Please ask for: Nicola Moore
Email: nicola.moore@arun.gov.uk
Telephone: Ext 37944
Our Ref: FP/241/20/HH
Your Ref:
Date: 21st December 2020

Application for Planning Permission for Works or Extension to a Dwelling

Development: Side dormer projection to existing first floor
Location: 32 Links Avenue Felpham PO22 7BX

sheet 1 a of 3

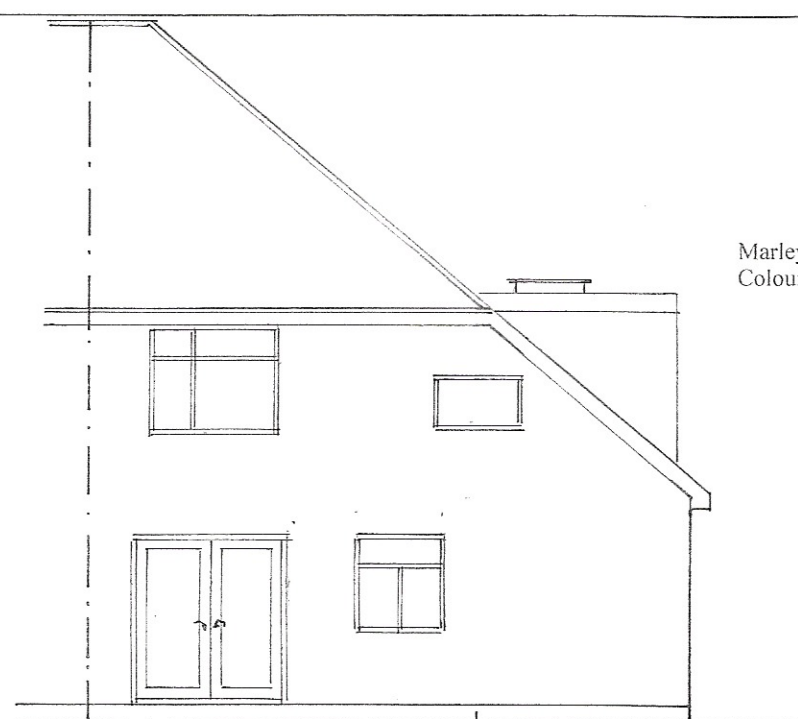
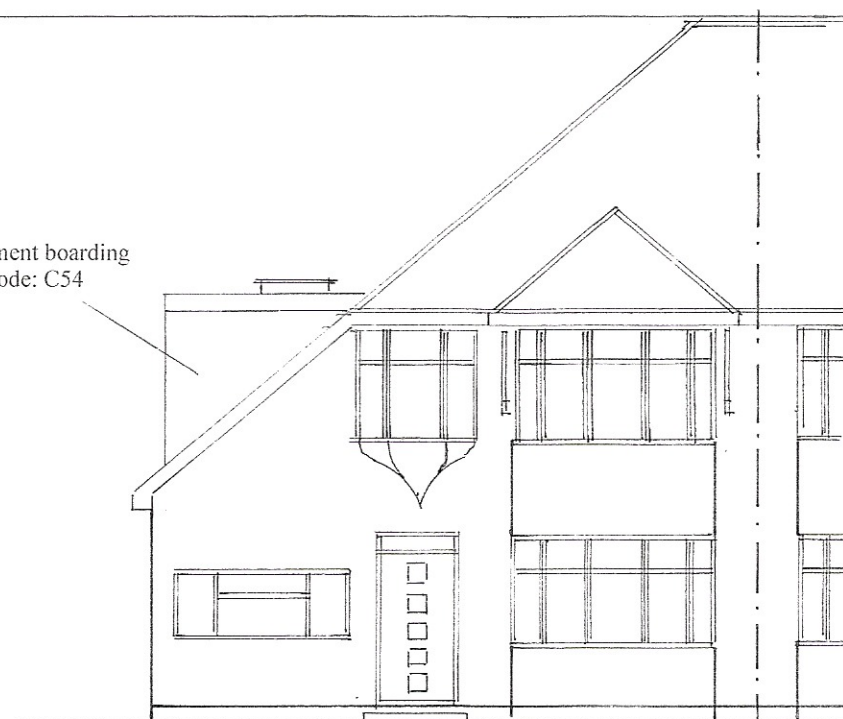
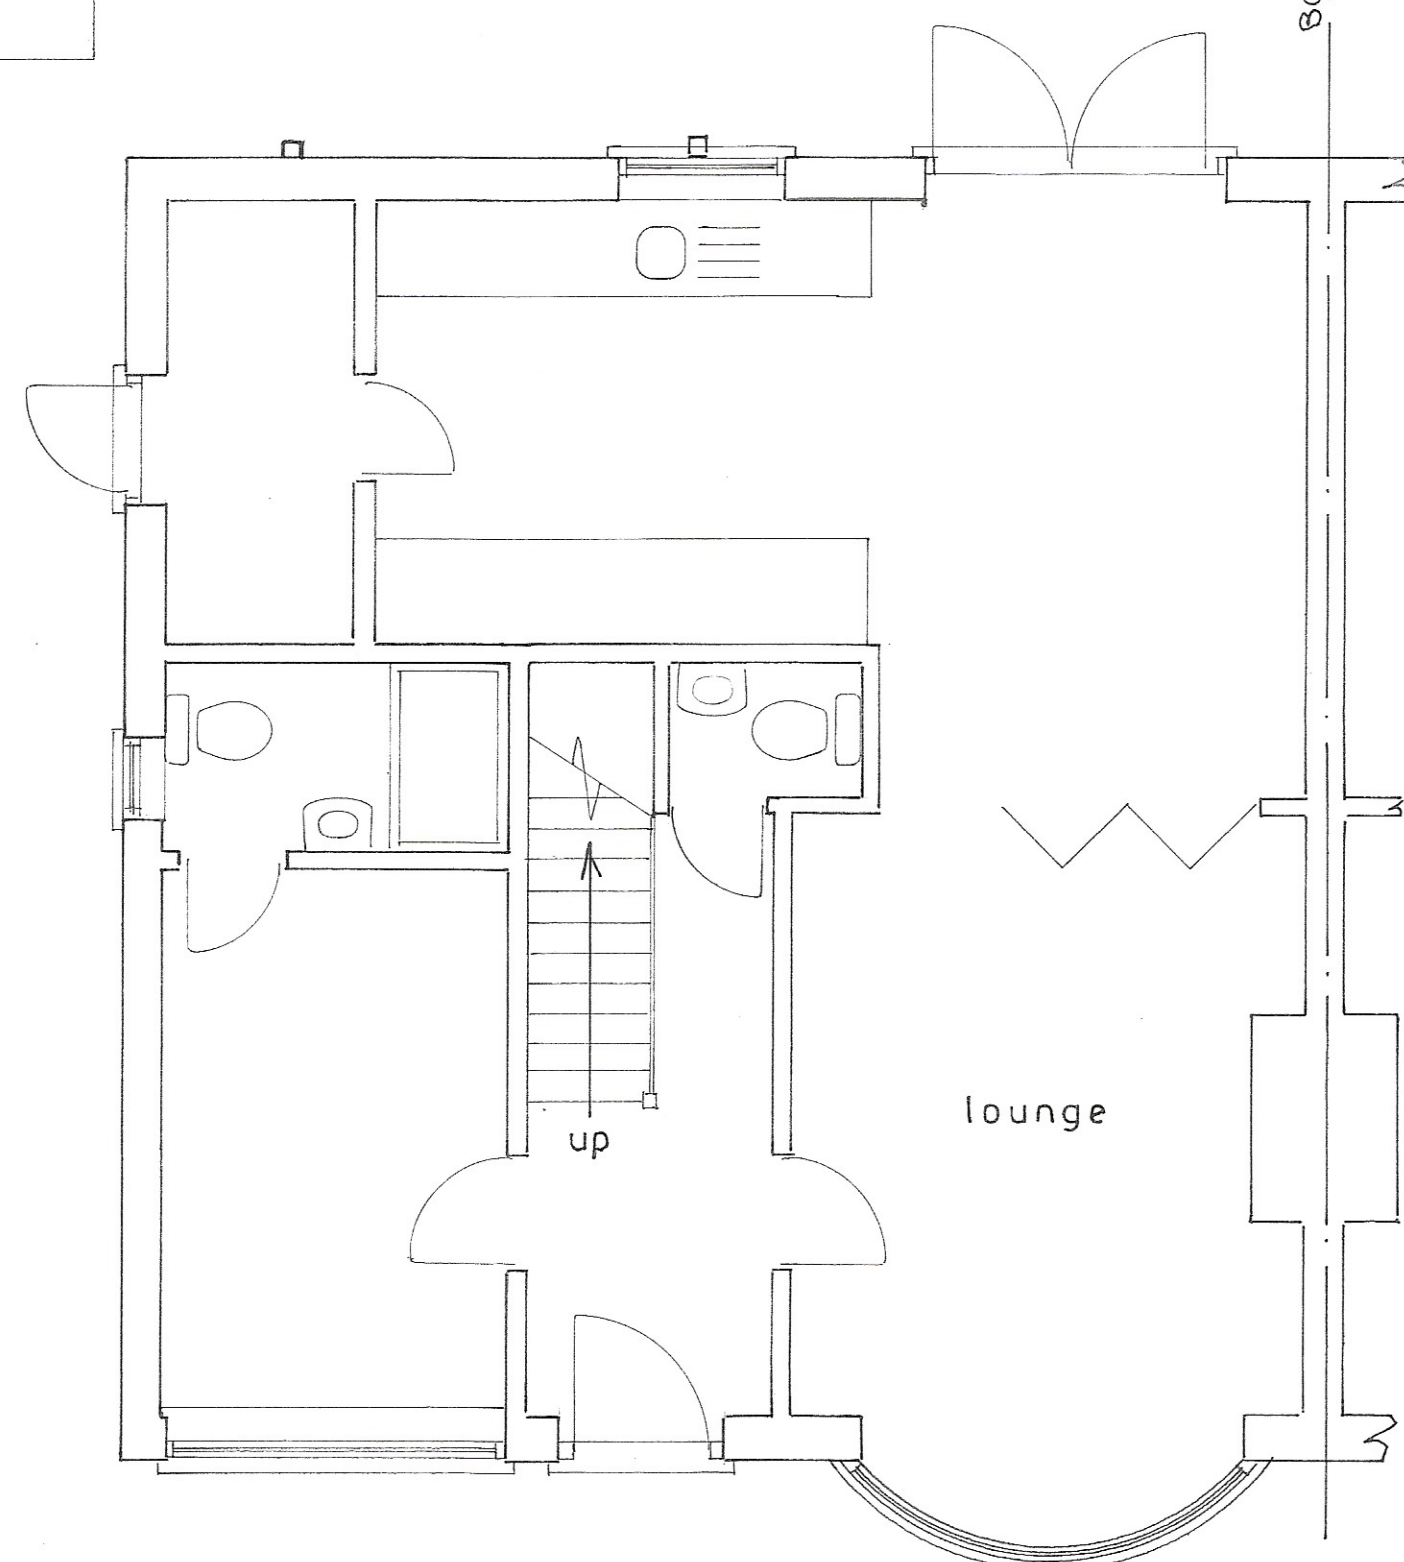
Please check the North, South and West aspect Elevations have been labelled correctly as on checking the front of the property appears to be on the West Elevation. Amend accordingly and resubmit, or clarify if correct.
